WEST SUSSEX COUNTY COUNCIL CONSULTATION

TO:	Arun District Council FAO: Amber Willard / Daniel Vick
FROM:	WSCC - Highways Authority
DATE:	17 May 2022
LOCATION:	Land to the rear of Clare Court, 67 Barnham Road, Eastergate, PO22 0EP
SUBJECT:	BN/16/22/PL Erection of 4 No dwellings with associated car parking. This application is in CIL Zone 2 and is CIL Liable as new dwellings. Amendments to Pedestrian Access
DATE OF SITE VISIT:	n/a
RECOMMENDATION:	Advice
S106 CONTRIBUTION TOTAL:	n/a

PROPOSED SITE PLAN . Scale 1:250 at A3

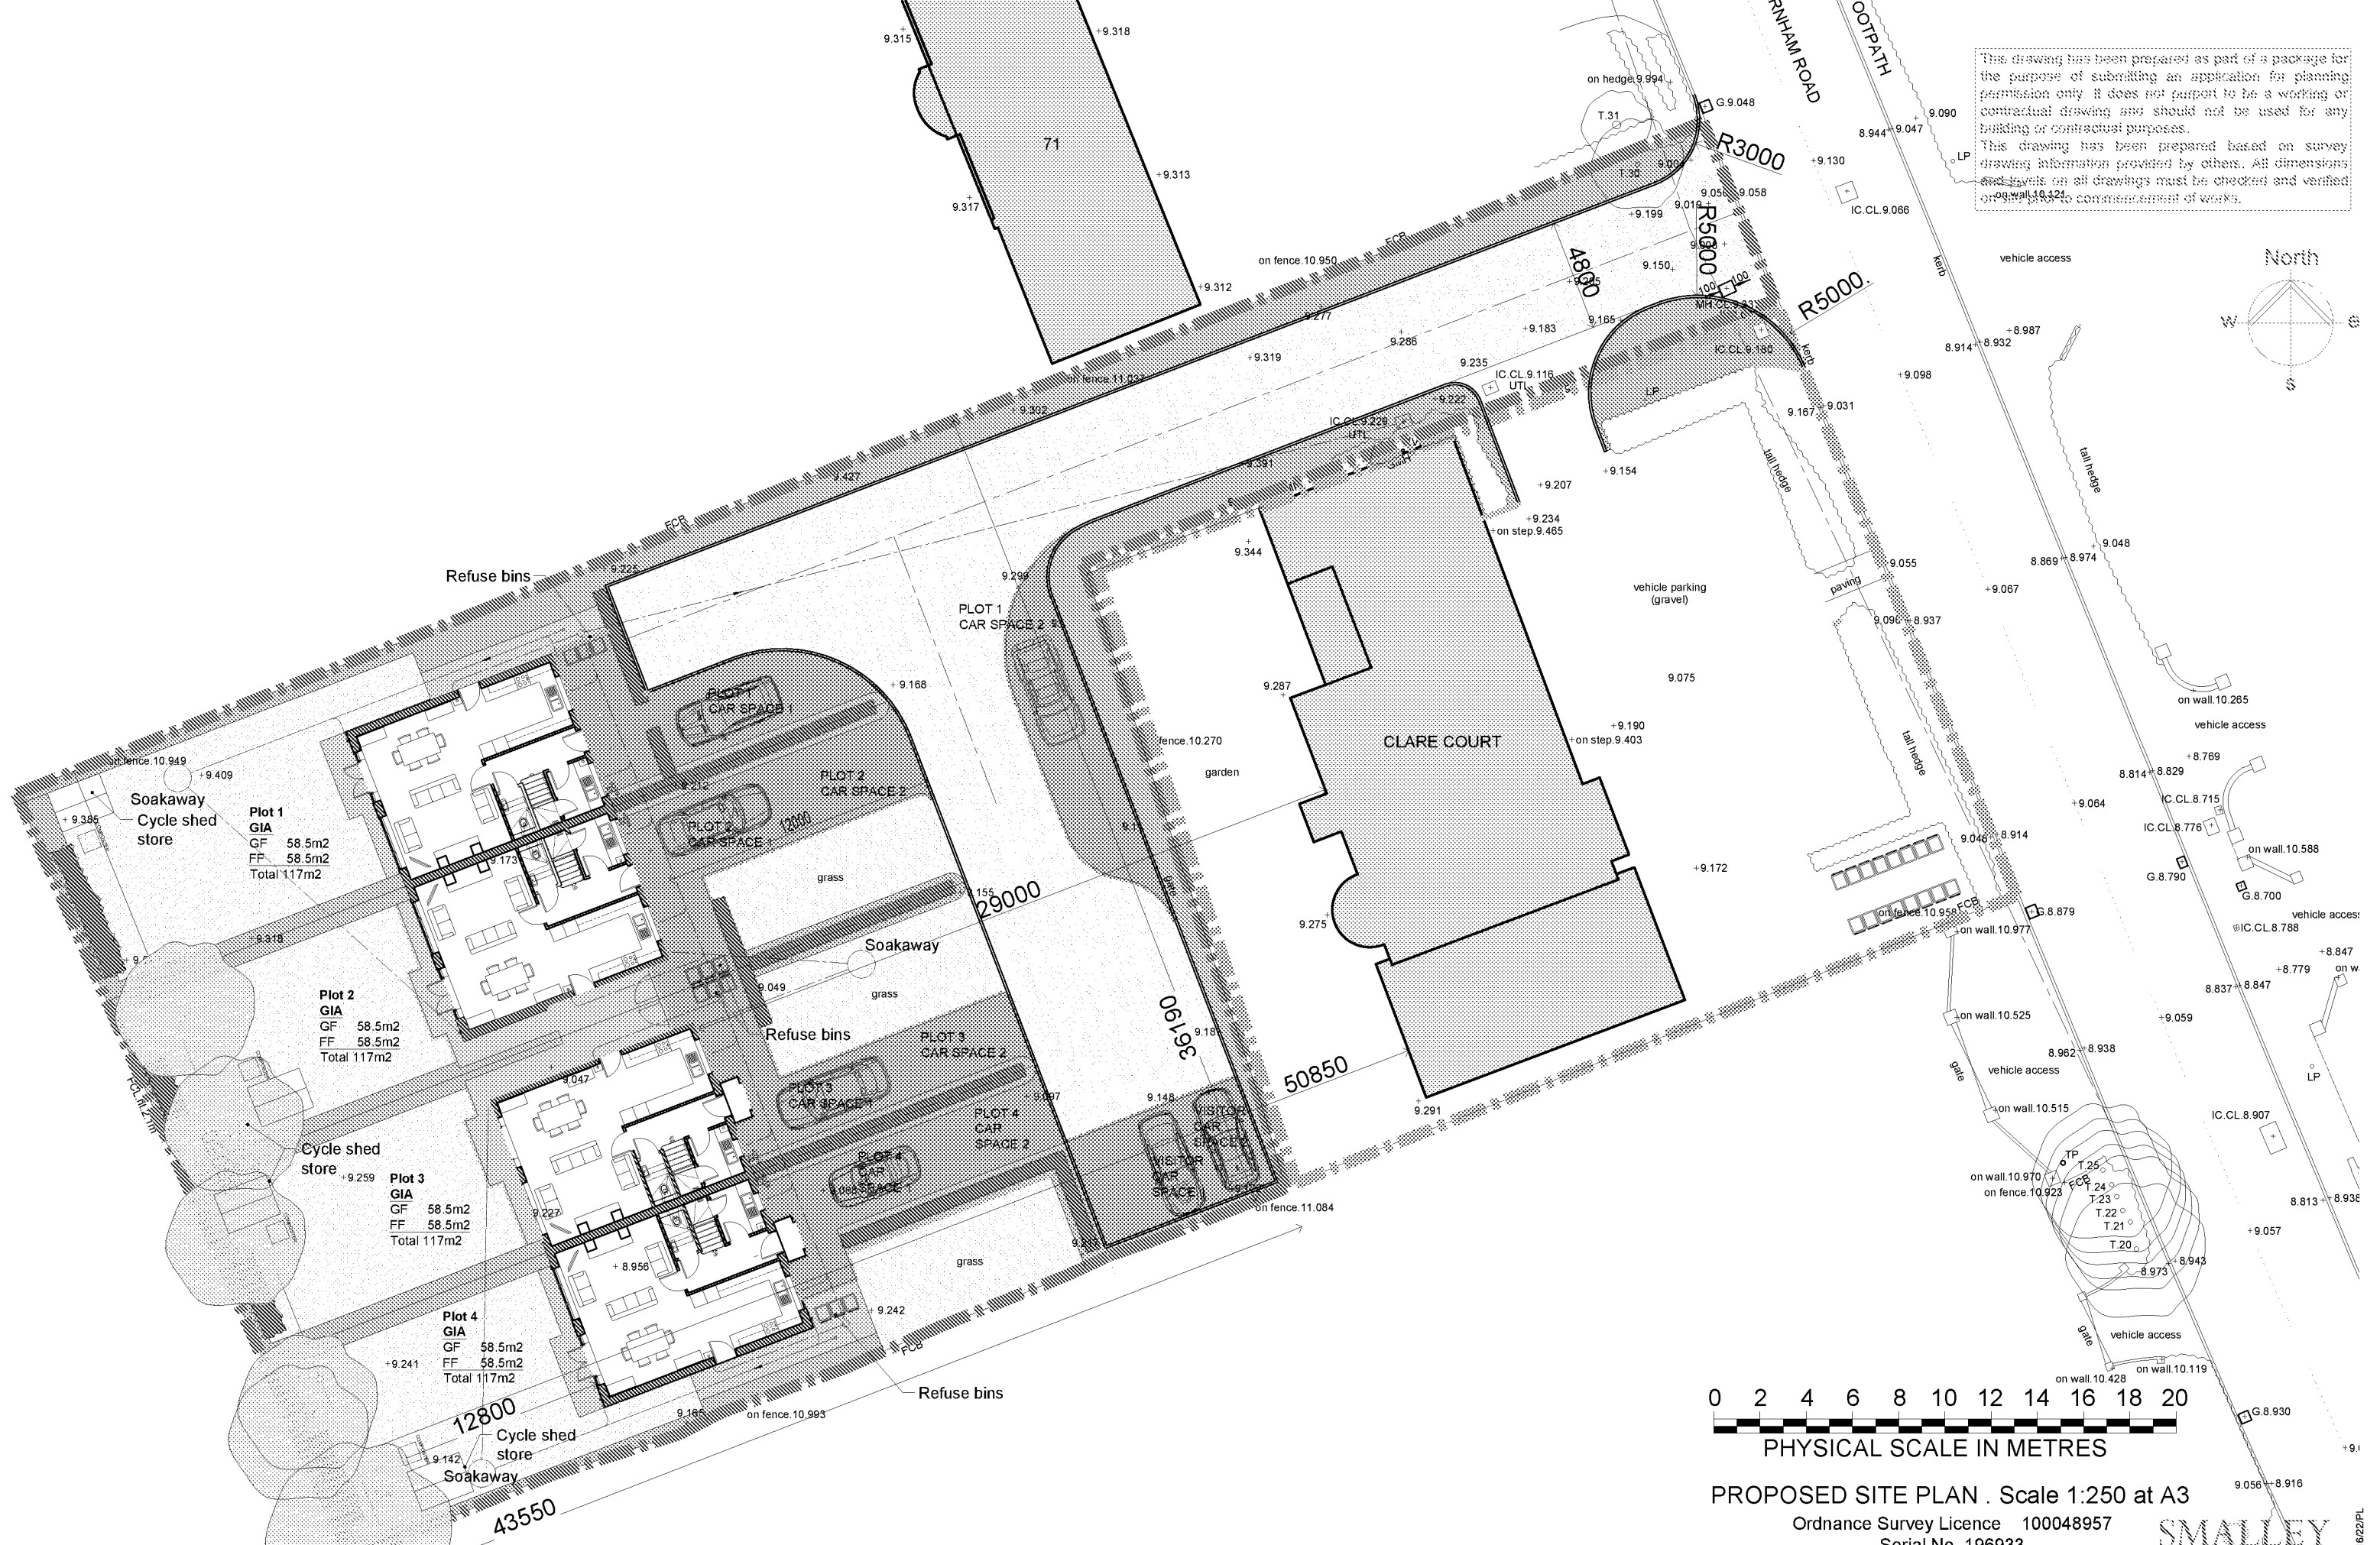
The latest plans detail that the access will be improved with a widened dropped crossing access point. The access way itself will measure circa 4.8 metres in width with the dropped crossing splaying to circa 6.75 metres in width.

An internal access width of 4.8 metres is considered wide enough to facilitate passing of two vehicles, and the passing of a vehicle sharing the space with pedestrians.

Within the site tracking has been provided to demonstrate that a refuse vehicle can turn within the confines of the site. This is considered acceptable.

Visibility splays of 2.4 x 43 metres have been demonstrated at the site access point. To the south the splay is contained within the extent of the public highway or under land under control of the applicant. To the north (trailing direction) it has been identified that the splay crosses 3rd party land.

To the north the maximum securable visibility splays have been demonstrated as 2.4 x 9 metres (measured using a 1.0 metre offset). A splay of 2.4 x 18 metres can be achieved if plotted using a 1 metre offset from the centreline.

After review of the site plan this quantum of parking is provided for. Each space is suitably sized and provided the opportunity to turn on site.

Each dwelling should be provided EV Parking provision in accordance with Arun DC Guidance. This has been detailed on the proposed site plans. The specific details of which can be secured via a suitably worded planning condition.

No part of the development shall be first occupied until such time as the vehicular access serving the development has been constructed in accordance with the details shown on the drawing titled SITE PLAN PROPOSED and numbered 1474/05g.
